****** FIELD CHANGE LETTER ******

PROJECT #: 21-3366-A

LOCATION: Lot 40, Woodbridge South

PLANS REF: Smithfield Plan by South Designs

S-1.1.2

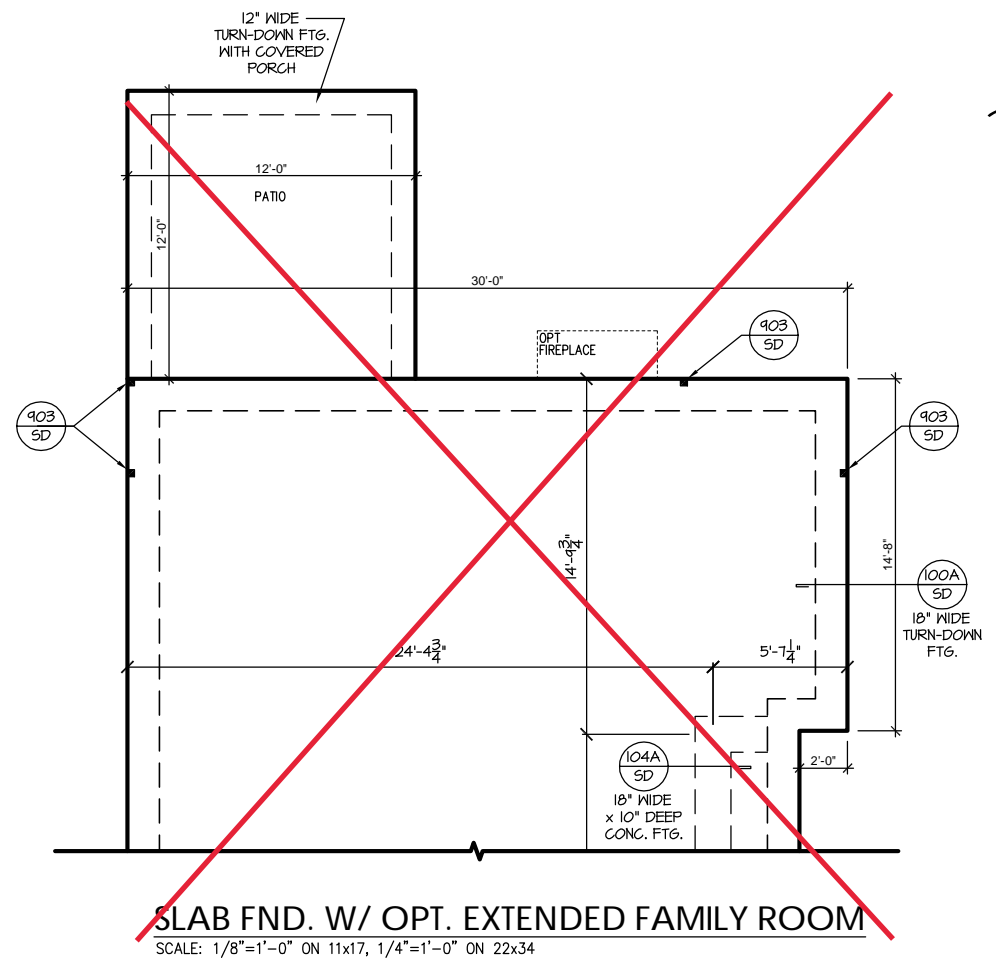
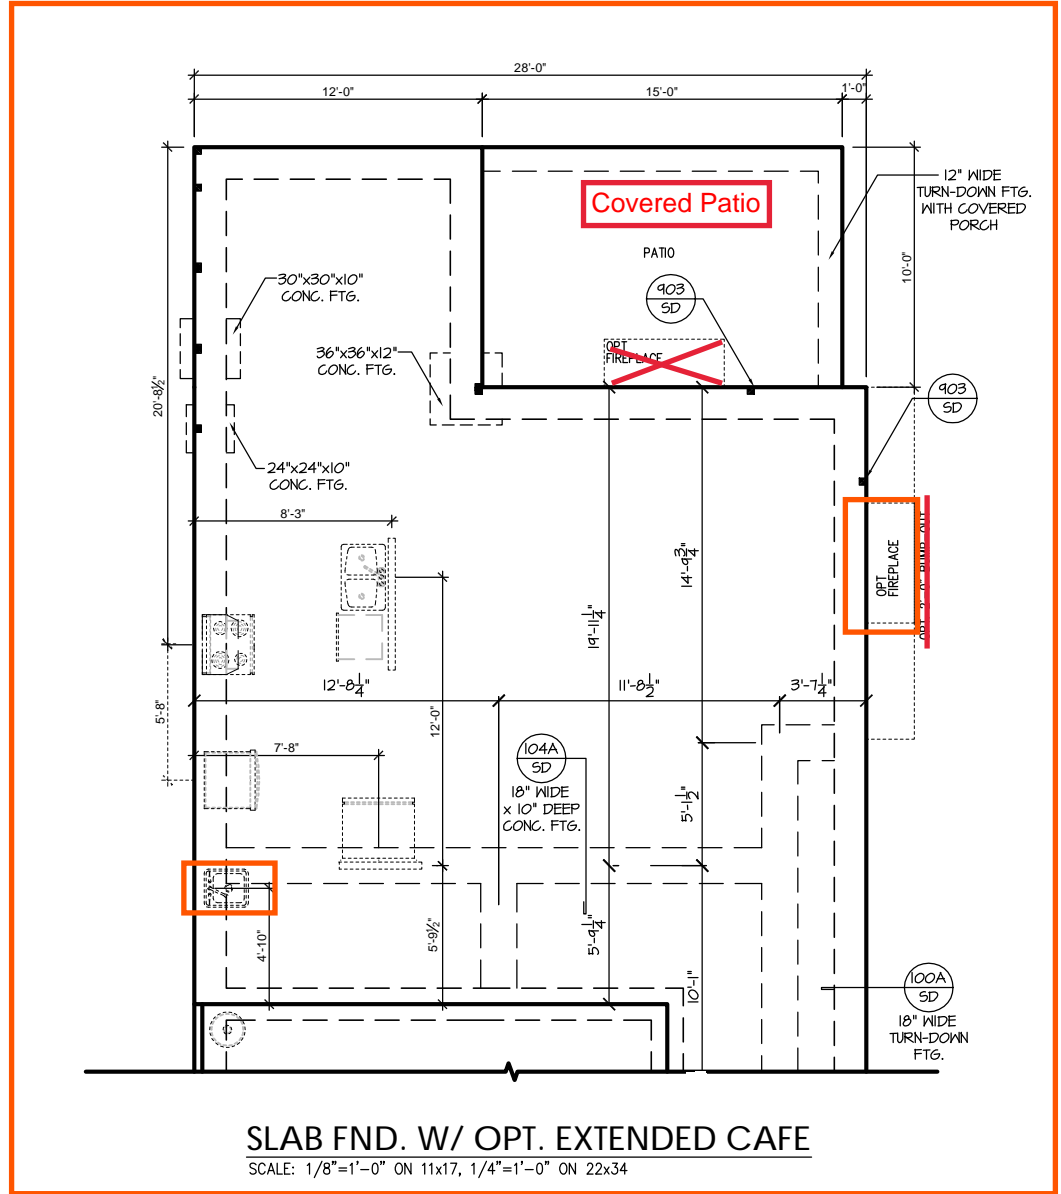
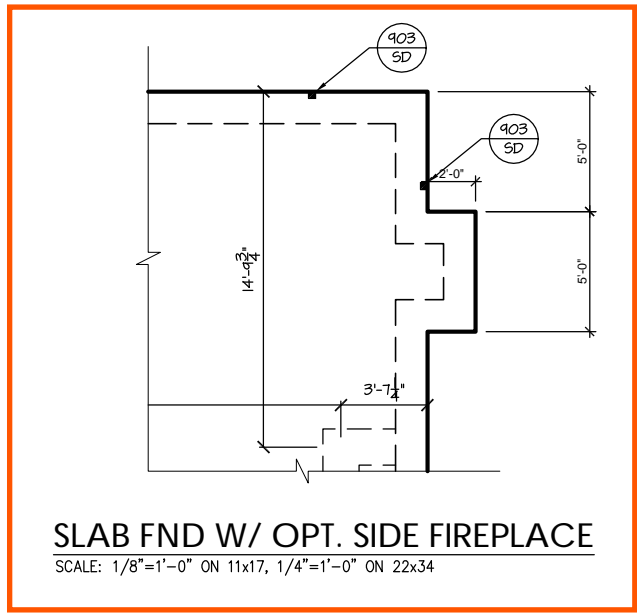
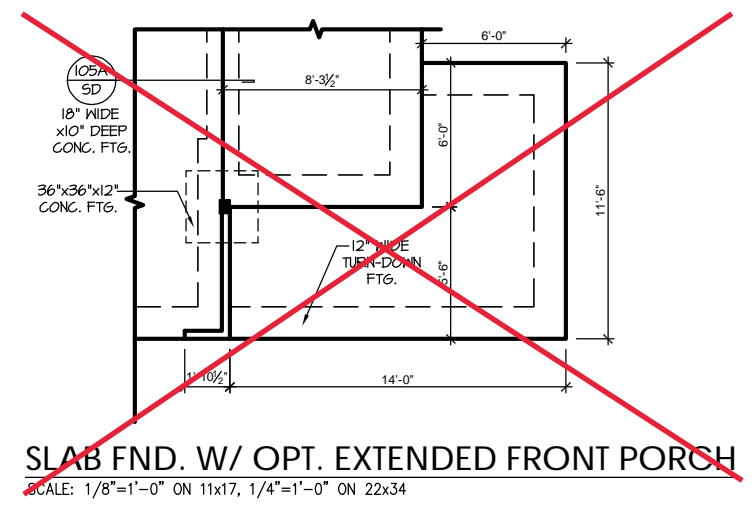
House to Garage Turndown Footing: Sheets S-1.1.2 of the plans shows a detail “105A/SD” between the house slab and the garage slab for the side entry garage option. The noted detail is for a thickened slab footing with a step down to the garage slab.

Based on information provided to Southern Engineers, the height from the top of the garage slab to the top of the house slab is approximately 22” and was not constructed per detail “105/SD”. The foundation between the house and garage was constructed as separate slabs, with the house slab having a 16” wide turndown footing as shown on detail “100A/SD” on the plans. The turndown footing was reinforced with (2) continuous #4 bar in the bottom of the footing and with #5 vertical bar @ 24” O.C. that bend and extend 24” into the house slab. The garage slab is a separate concrete pour that butts up to the side of the turndown footing of the house.

Response: Please note that the above described house to garage turndown footing is structurally acceptable.
